**Lancashire
Constabulary**

Rachel Emmett
Architectural Liaison Office
Lancashire Constabulary
Saunders Lane
Hutton
Preston
Lancashire
PR4 5SB
01772 412 892
07432629040

Crime Impact Statement Planning Application 3/2013/0161

PHASE 2 - PROPOSED SITE PLAN

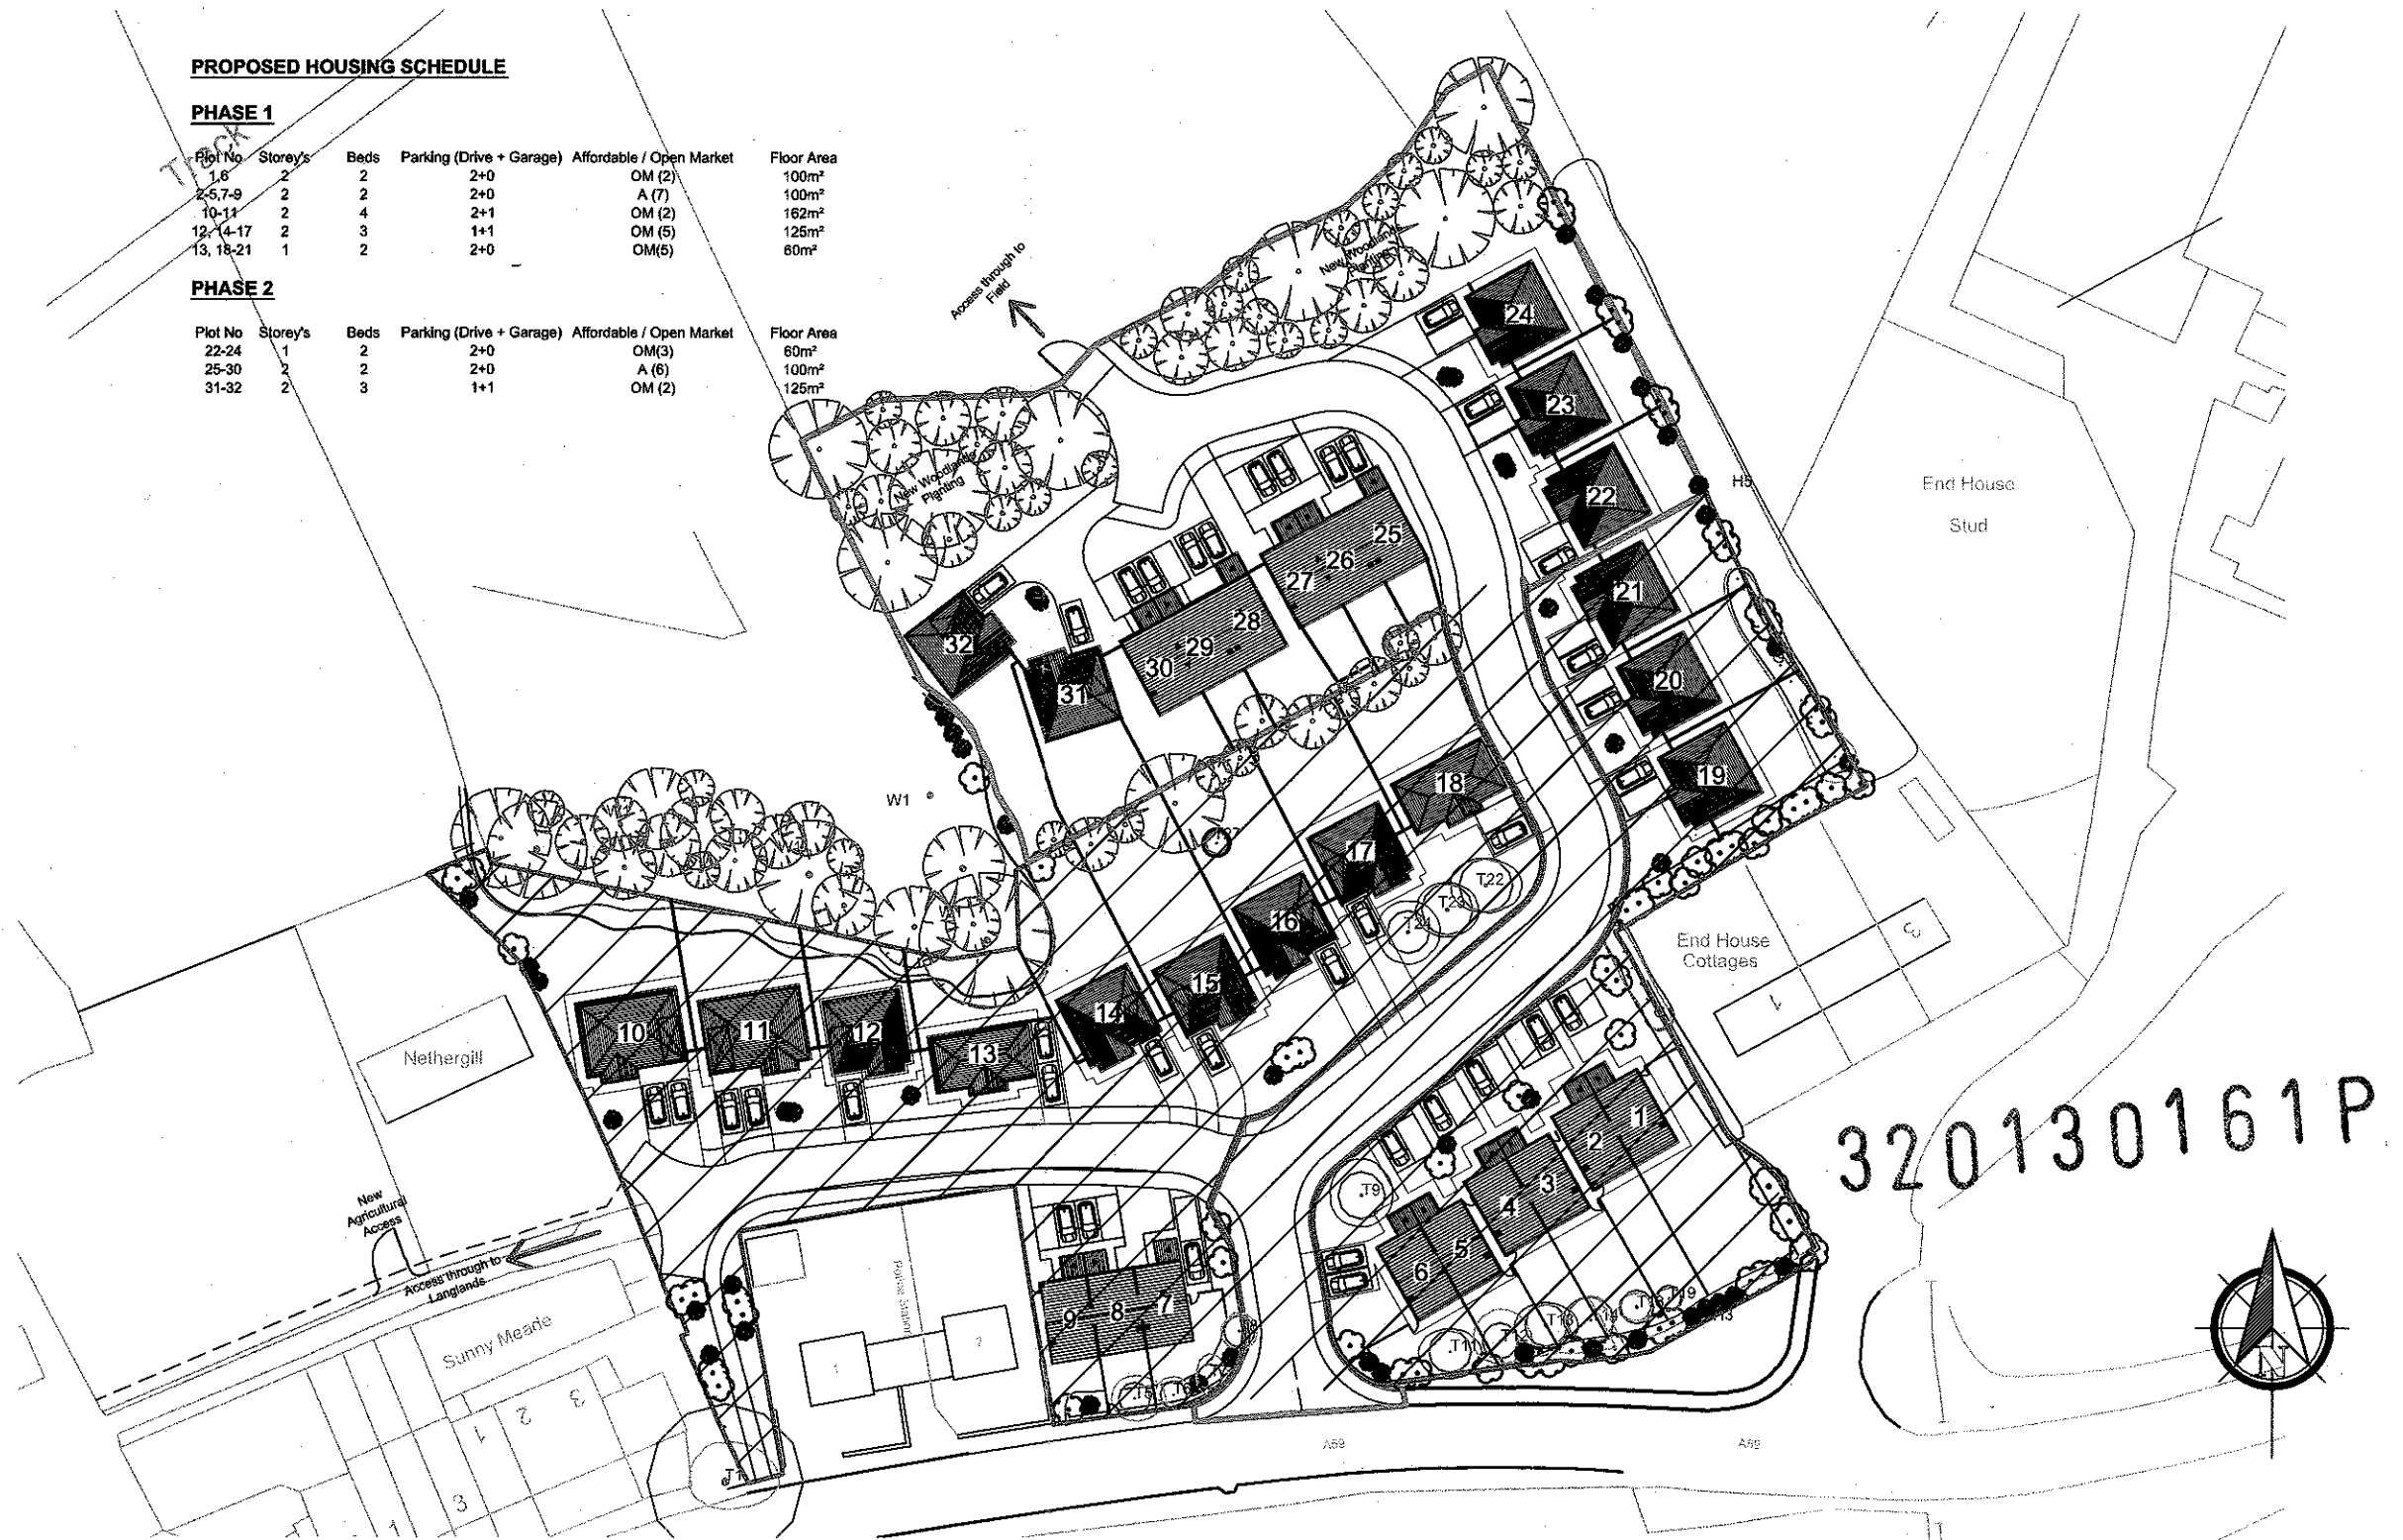
The layout reflects this as rear access alleys have been avoided, the gardens are back to back and natural surveillance has been optimised. The cul de sac layout is also supported as intruders are more likely to stand out and be challenged.
